Please ask for: Nicola Moore
Email: nicola.moore@arun.gov.uk
Telephone: Ext 37944
Our Ref: P/60/22/PL
Your Ref:
Date: 6th May 2022

Application for Planning Permission

Development: Replace existing conservatory with front porch, single storey rear extension and dormer windows. Extension of existing garage and part conversion to tourist accommodation. This application may affect the setting of a Listed Building.
Location: Grey Barn Church Lane Pagham PO21 4NX

PROPOSED SOUTH ELEVATION

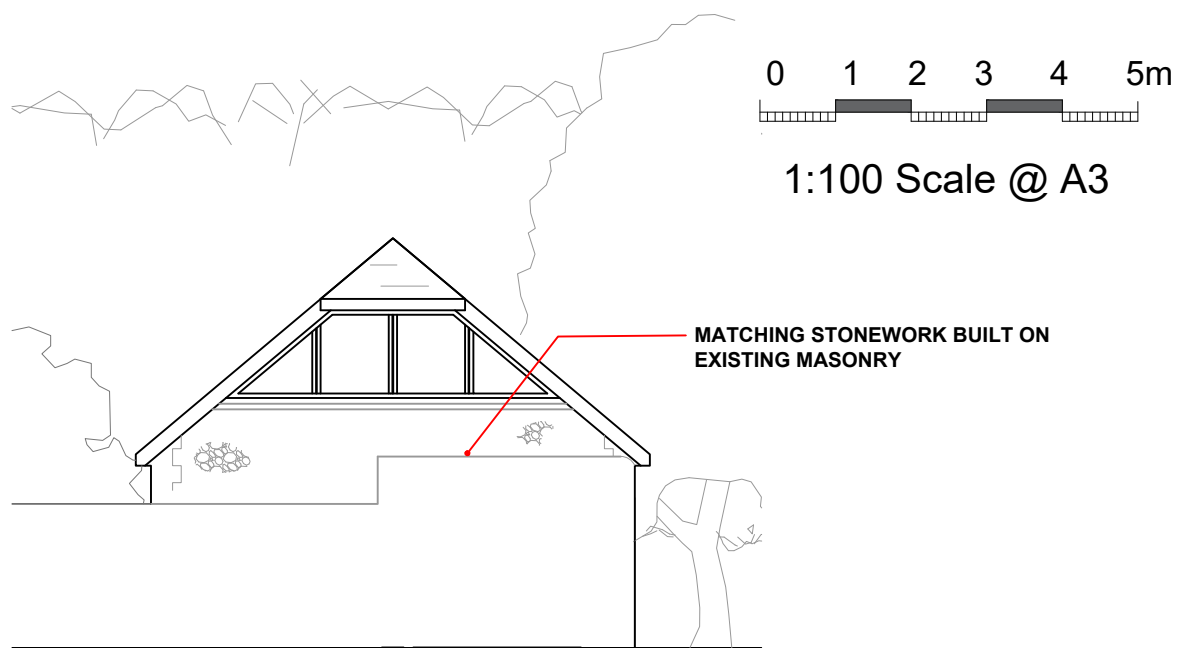
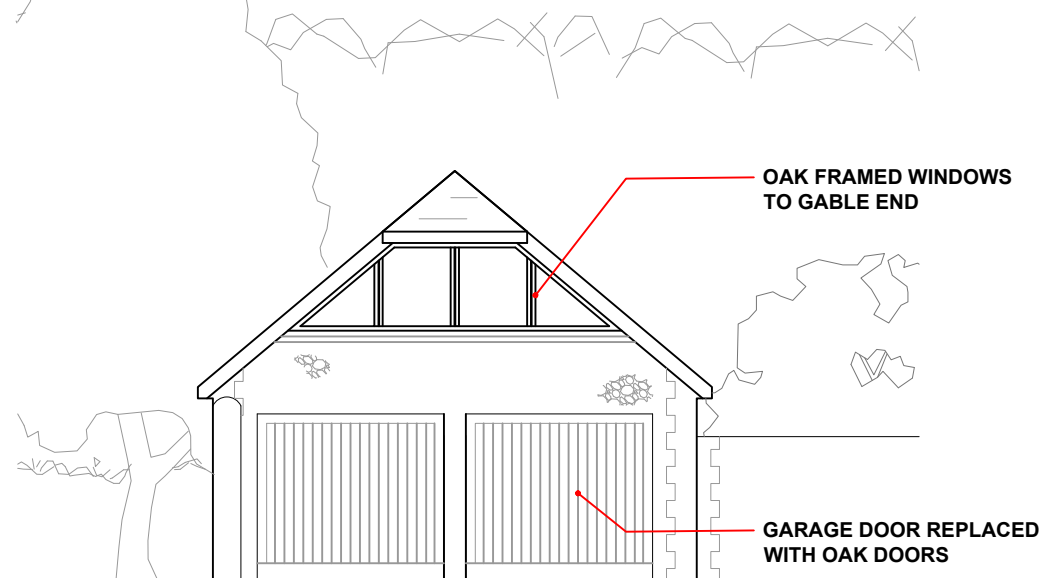
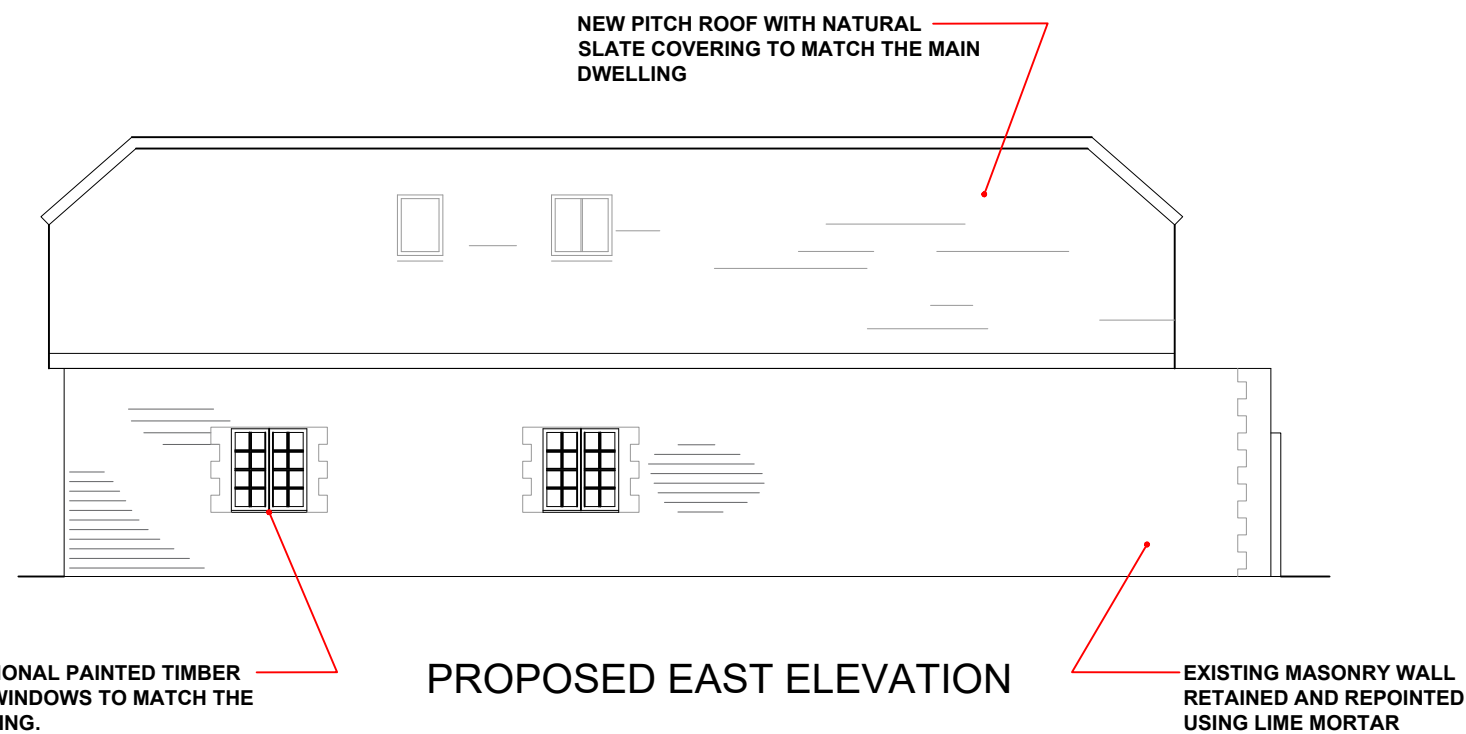
Dwg No N.1130-05 is titled as Existing Elevations, but the individual elevations are labelled Proposed. Please amend accordingly and re submit.
